Re: Planning Application 18/1123

Address: Land rear of Rocklea and Standridge Whalley Road Billington BB7 9NA

Description: Application for the discharge of condition 3 (materials), 4 (landscaping), 8 (construction method statement) and 11 (construction and design of external refuse recycling/bin stores) from planning permission 3/2018/0296.

DOCUMENT 1

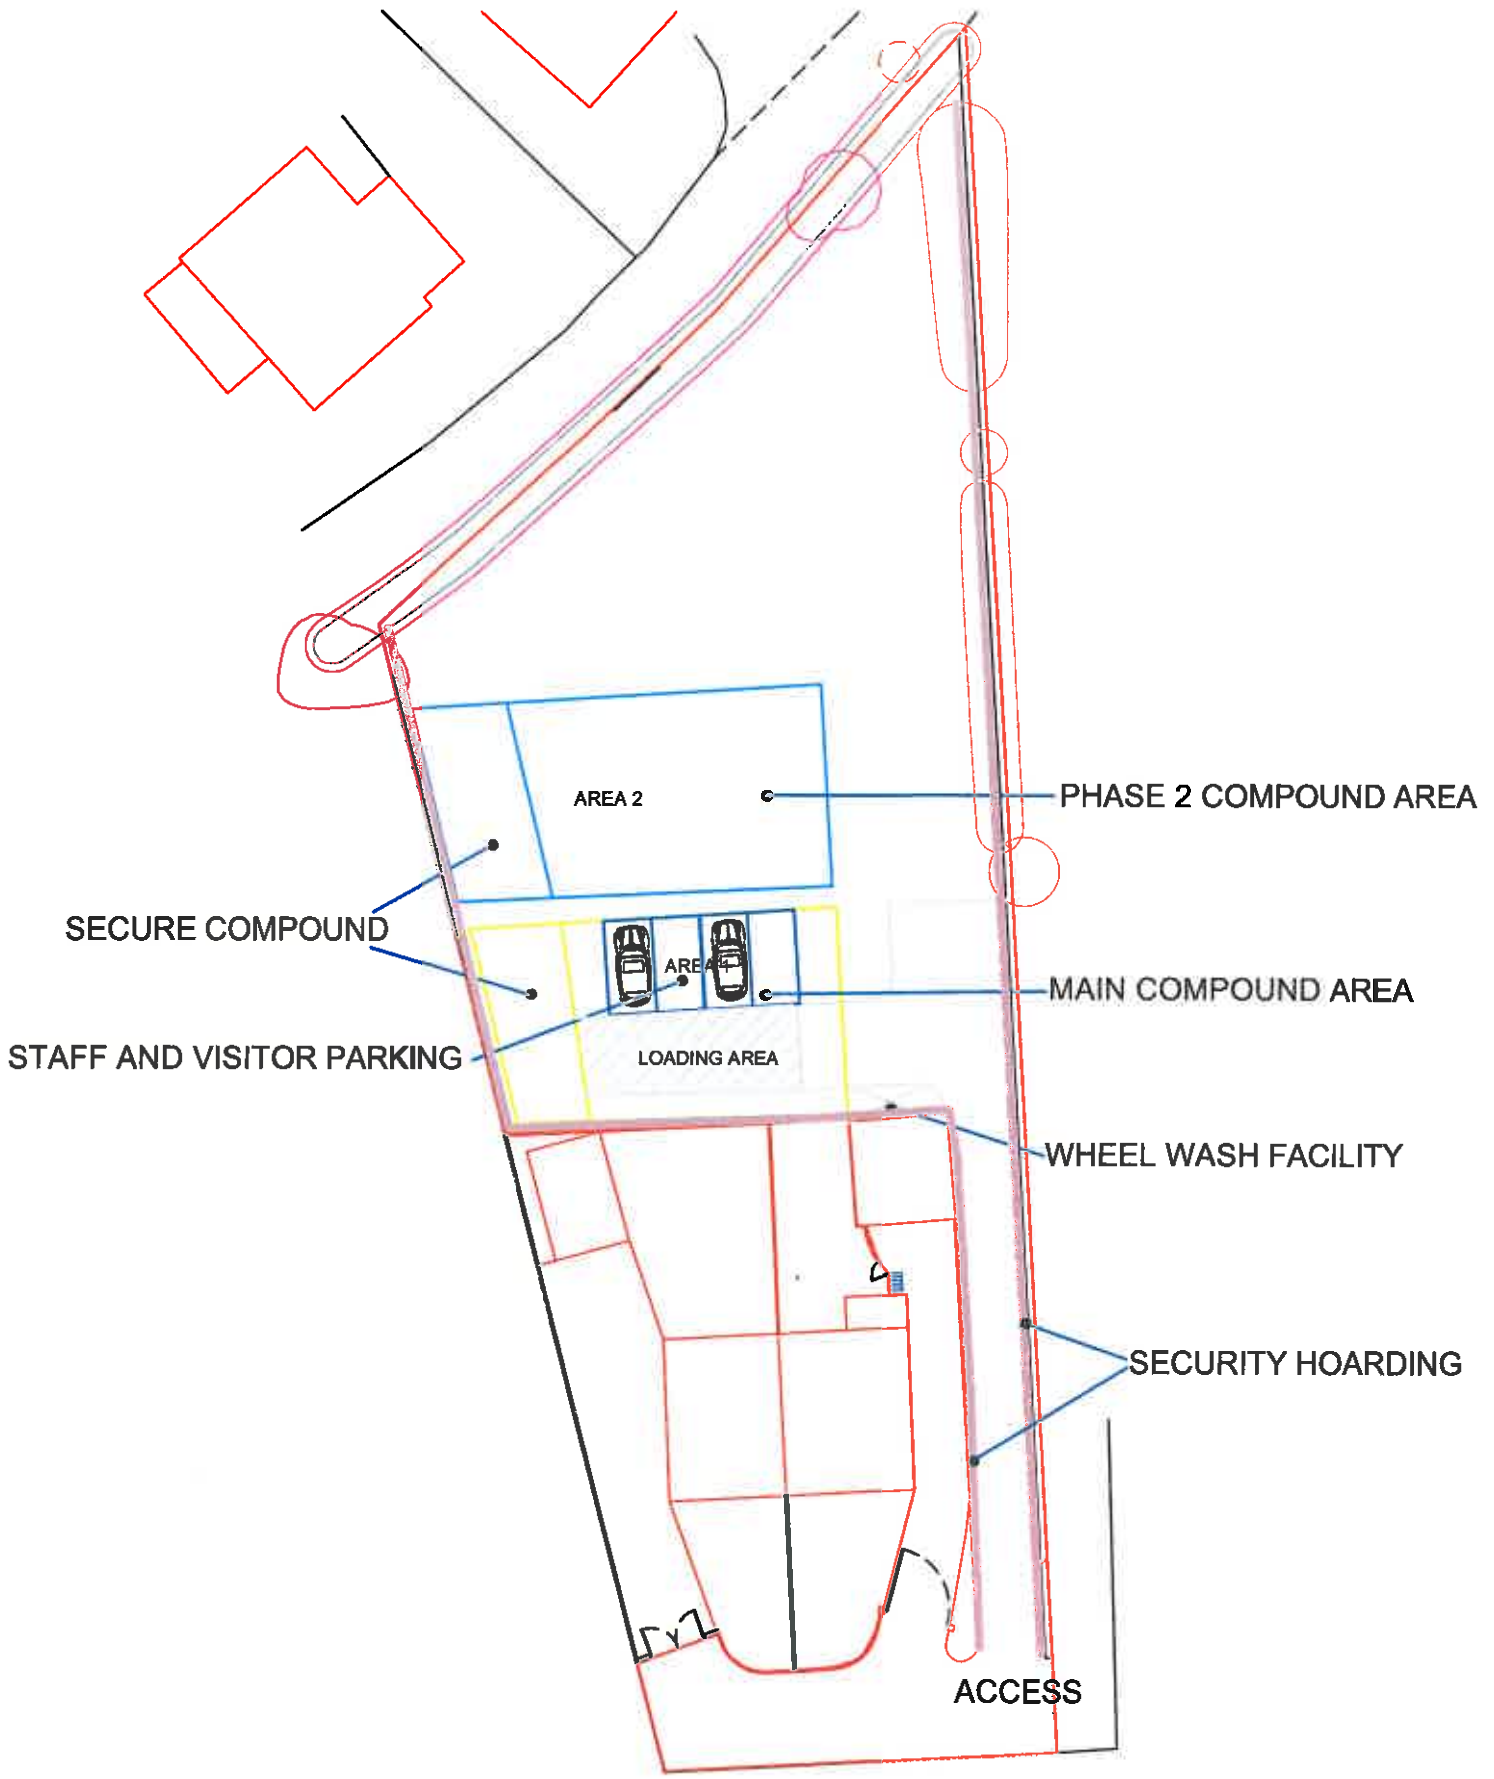
It would appear from the information supplied that the Compound areas are the same areas that are to become the building plots. Details of how the site is to function throughout the building period would be expected in order to progress the application. It is noted that the access to the site is across a restricted zig-zag area of the zebra crossing which restricts the available on street parking.
